**From:** Sarah Featherstone [REDACTED]  
**Sent:** 27 September 2019 10:12  
**To:** Anita Gardner <[Anita.Gardner@arun.gov.uk](mailto:Anita.Gardner@arun.gov.uk)>  
**Cc:** Martyn White <[Martyn.White@arun.gov.uk](mailto:Martyn.White@arun.gov.uk)>  
**Subject:** Mill Cottage applications CM/38/19/PL and CM/39/19/L

We have read through Martyn White's (Conservation officer) comments on Mill Cottage applications CM/38/19/PL and CM/39/19/L which are very useful and encouraging and we would like to confirm and respond as follows:

**Mill Cottage:**

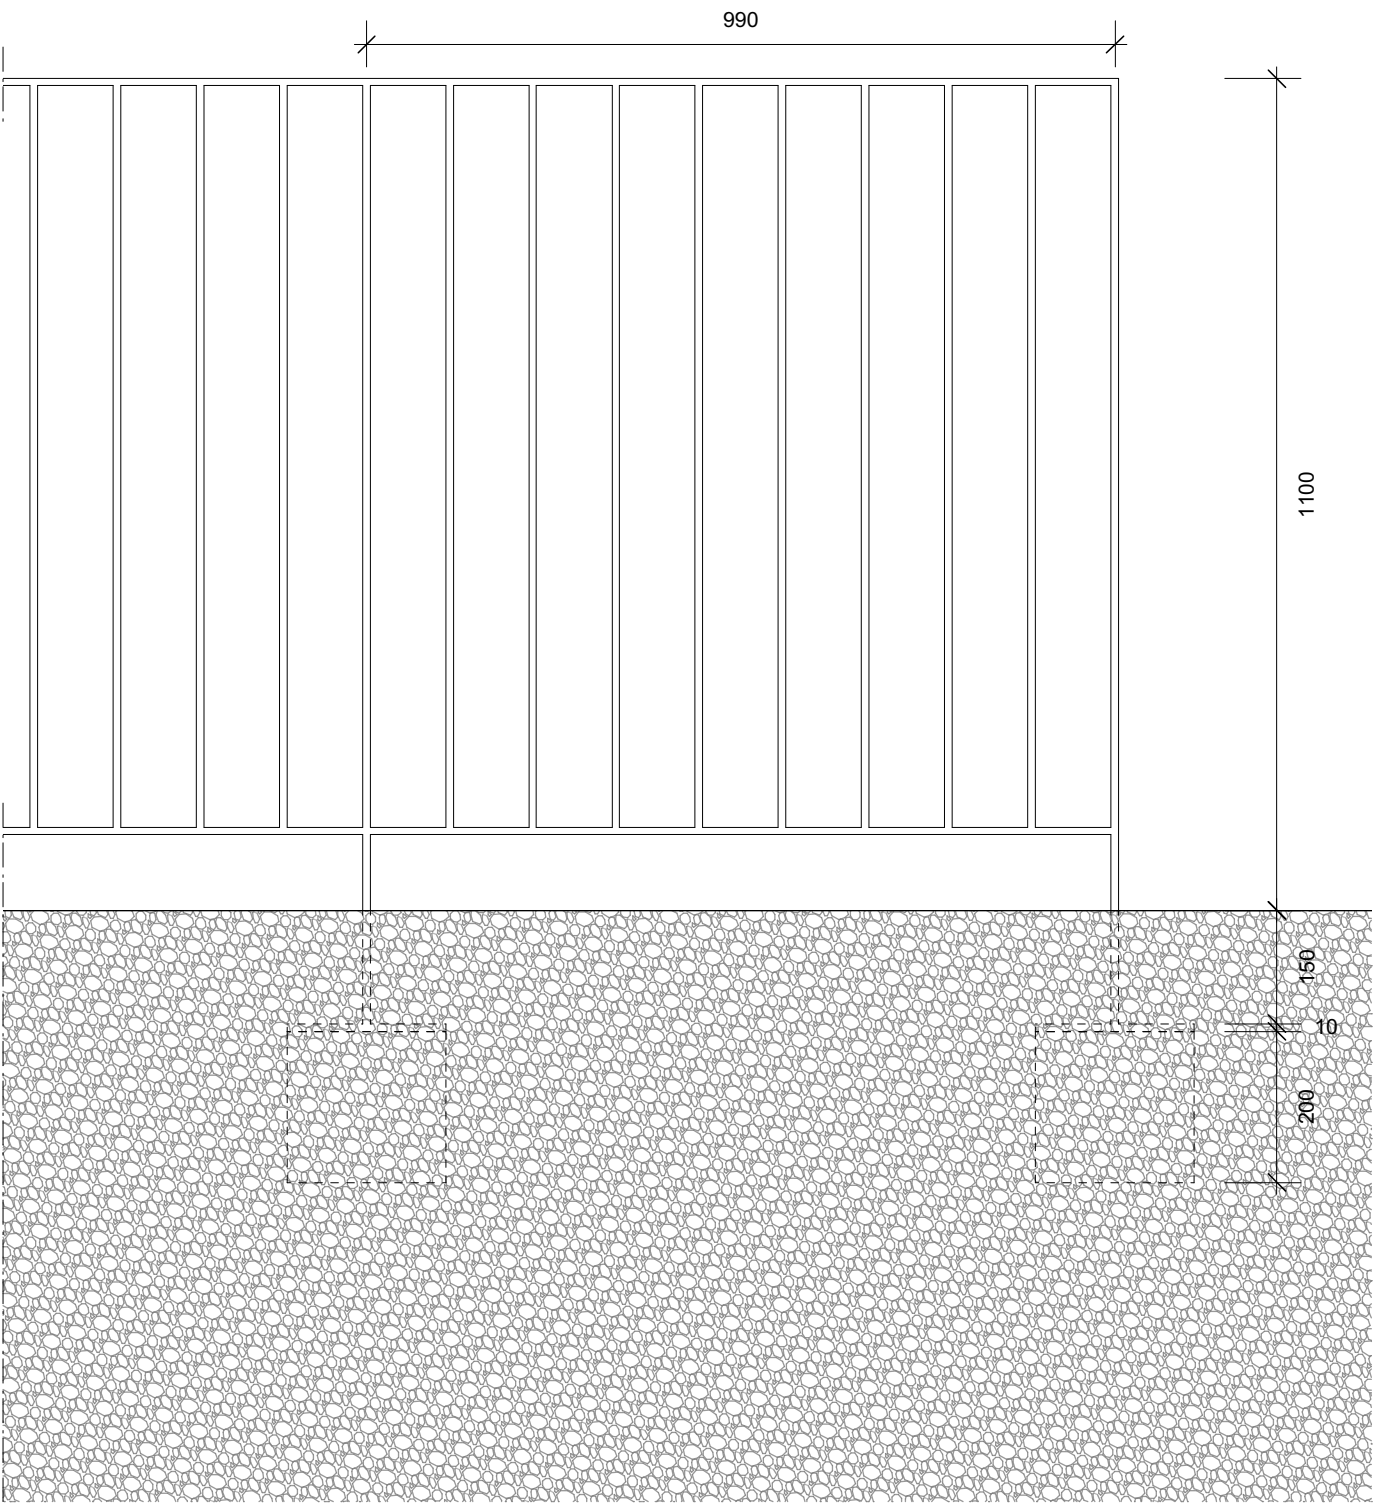
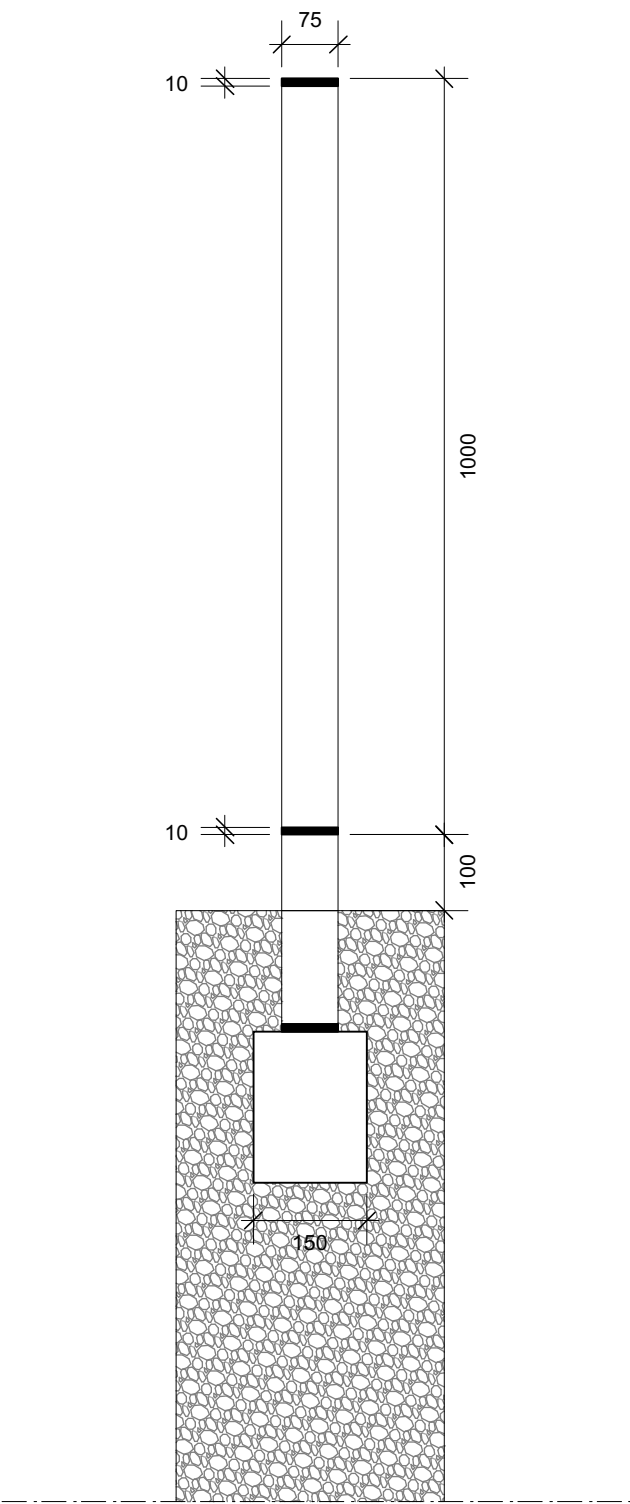
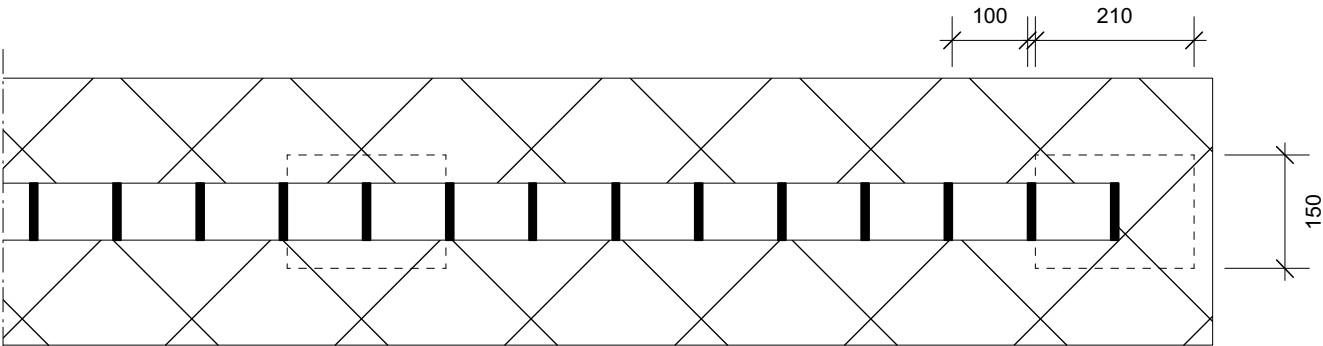
- Internal flooring - we confirm the floors are replacement concrete slab with polished concrete screed finish.
- We can confirm the balustrade will be painted not sprayed.
- 
- **2. Additional details which we can issue next week:**
- Shutters detail to windows in flint walls
- Detail of stone paving specification on external terrace
- 
- **3. Samples:**
- We can provide a sample panel of new walling to front terrace - can this be a condition prior to commencement of this part of work only?
